STANBURY
TRAFFIC PLANNING

29 April 2020

PARKING AND TRAFFIC ASSESSMENT
STATE SIGNIFICANT DEVELOPMENT 10260
PROPOSED PRIMARY SCHOOL
211 PACIFIC HIGHWAY, ST LEONARDS

STANBURY TRAFFIC PLANNING
MEDIUM RIGID VEHICLE SWEEP PATHS
SITE INGRESS MOVEMENT
PROPOSED PRIMARY SCHOOL
211 PACIFIC HIGHWAY, ST LEONARDS

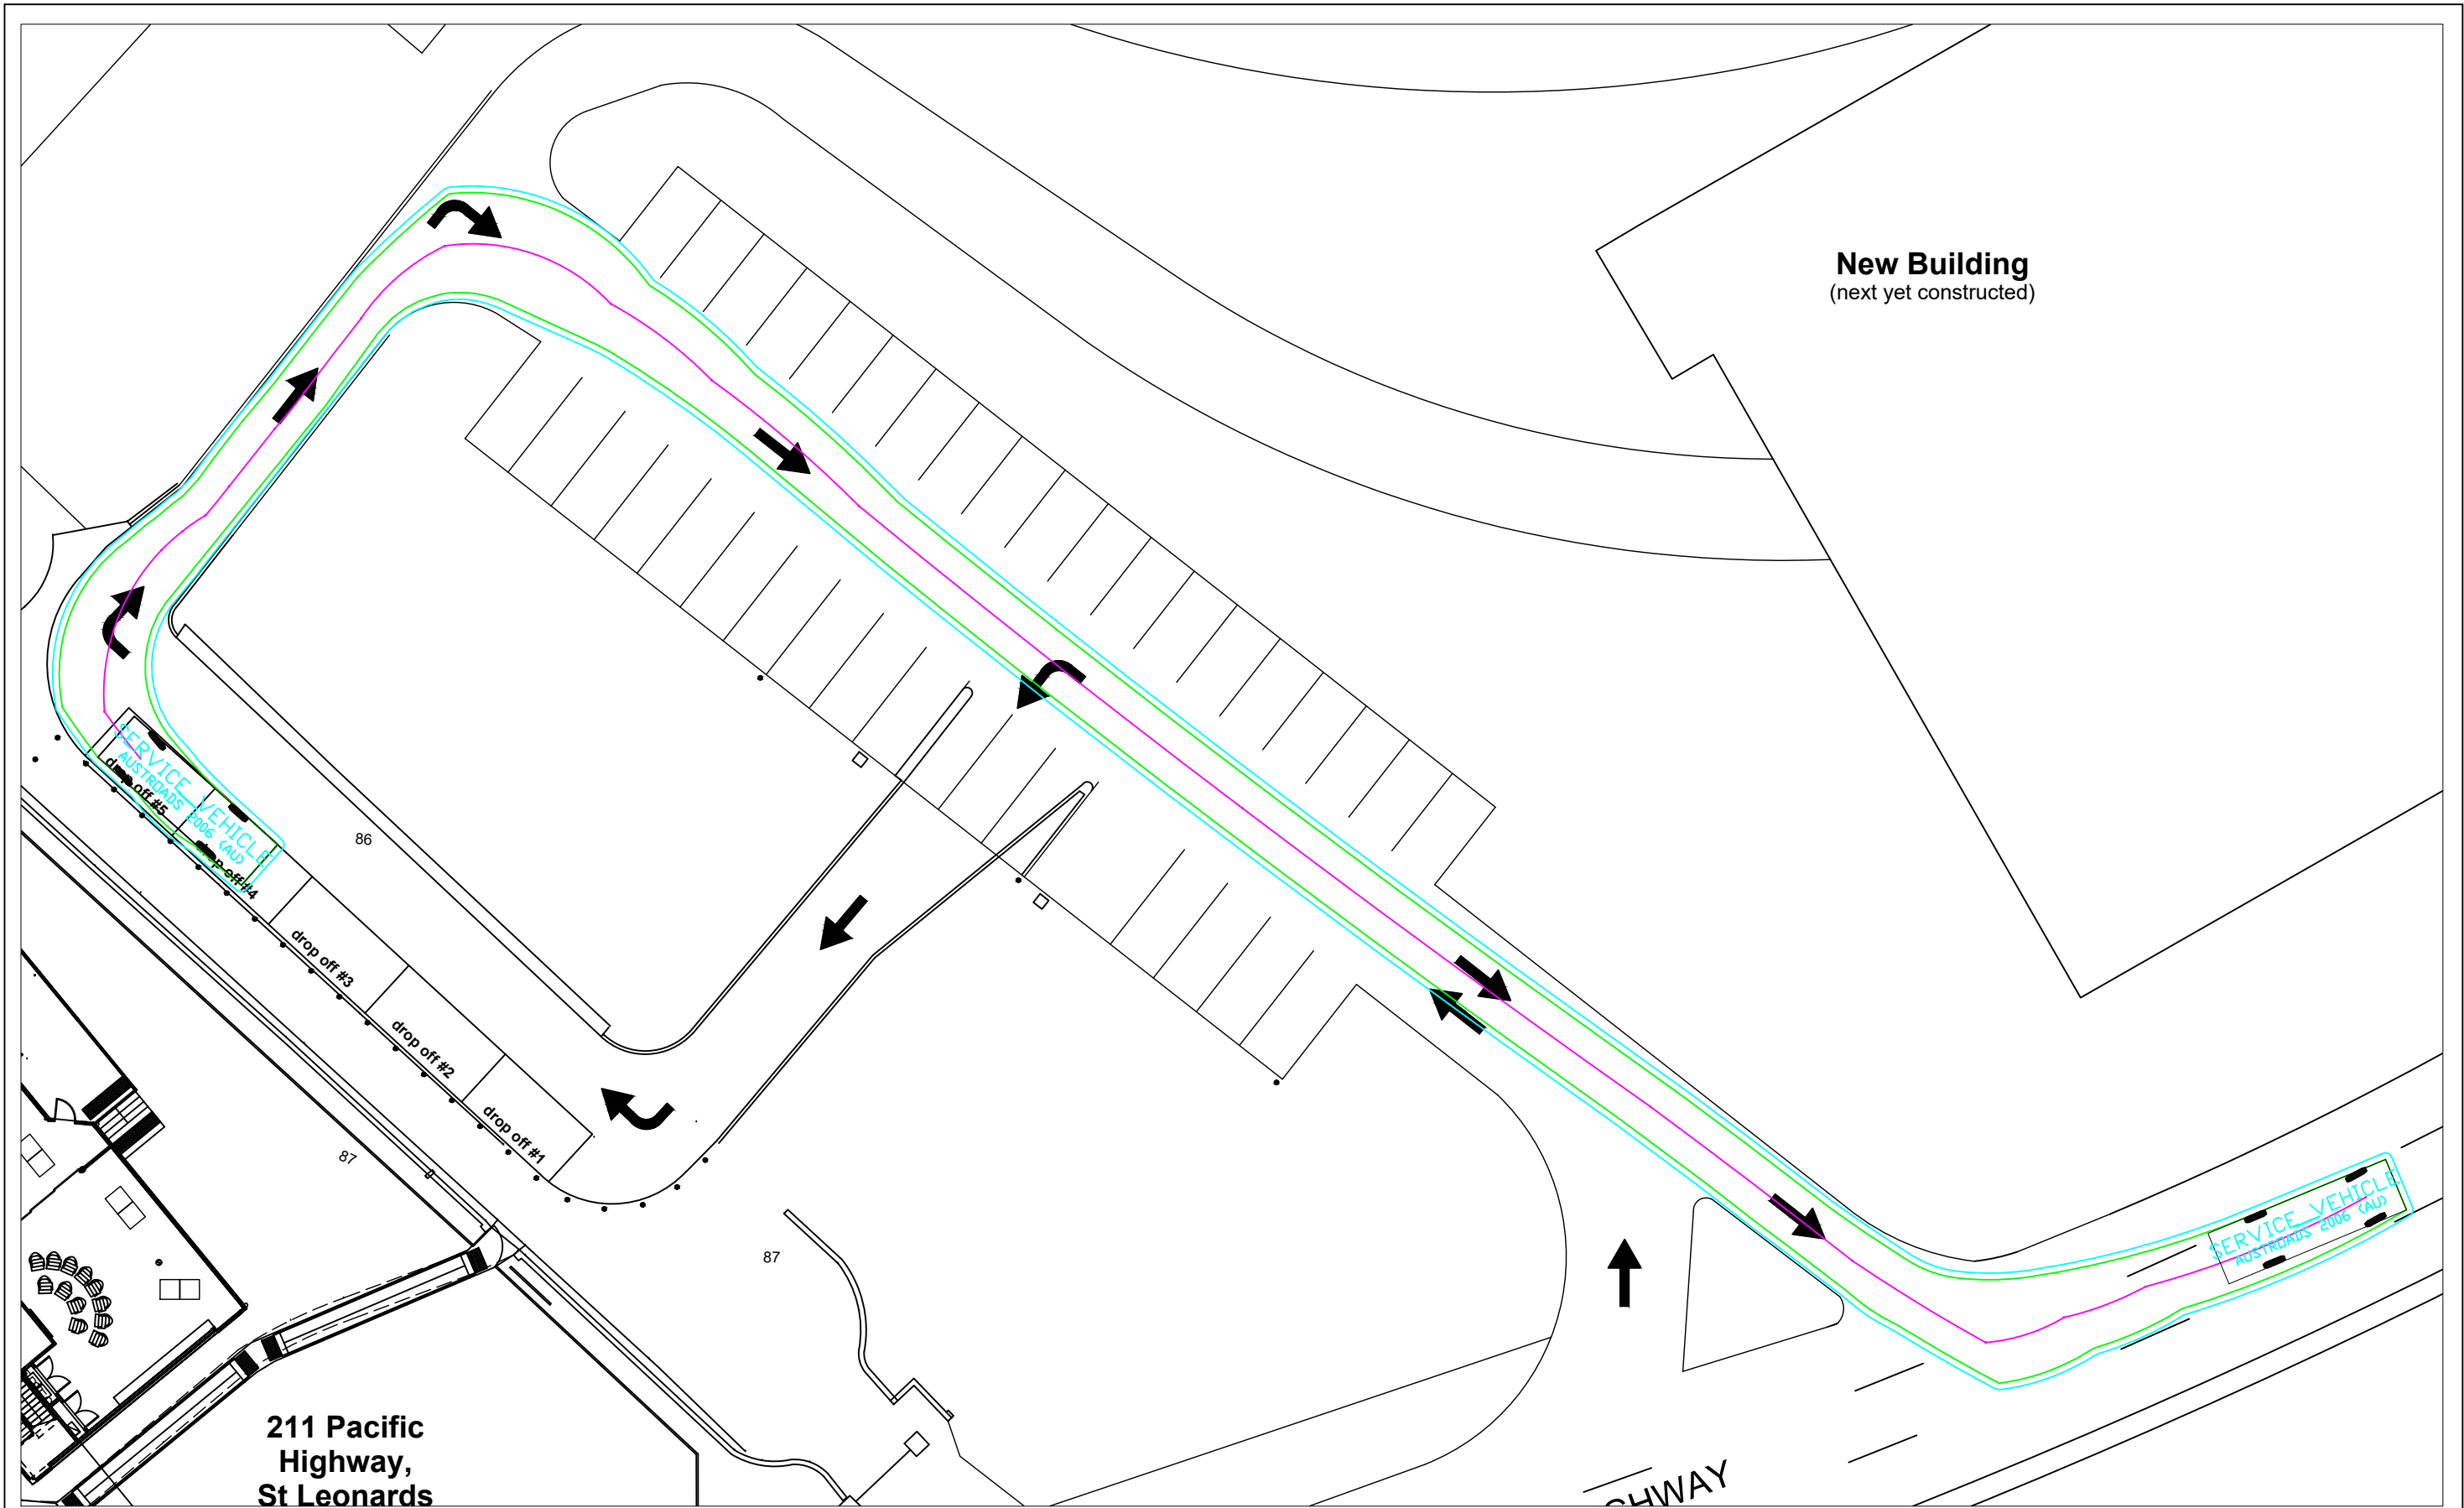
Issue 5: The submitted swept path plans for egress to the Council car park onto the Pacific Highway are not acceptable. Roads and Maritime request amended plans clearly showing that Medium Rigid Vehicles can safely enter and exit the carpark via the kerbside lane of the Pacific Highway.

Comment: Amended swept paths have been prepared and are included within and attached as **Attachment 2** of the Updated Assessment to reflect the amended development design, including the proposed deceleration lane. These swept path plans illustrate that MRVs are capable of entering the Council car park access driveway from the deceleration lane thereby not impacting trailing through eastbound Pacific Highway traffic flow.
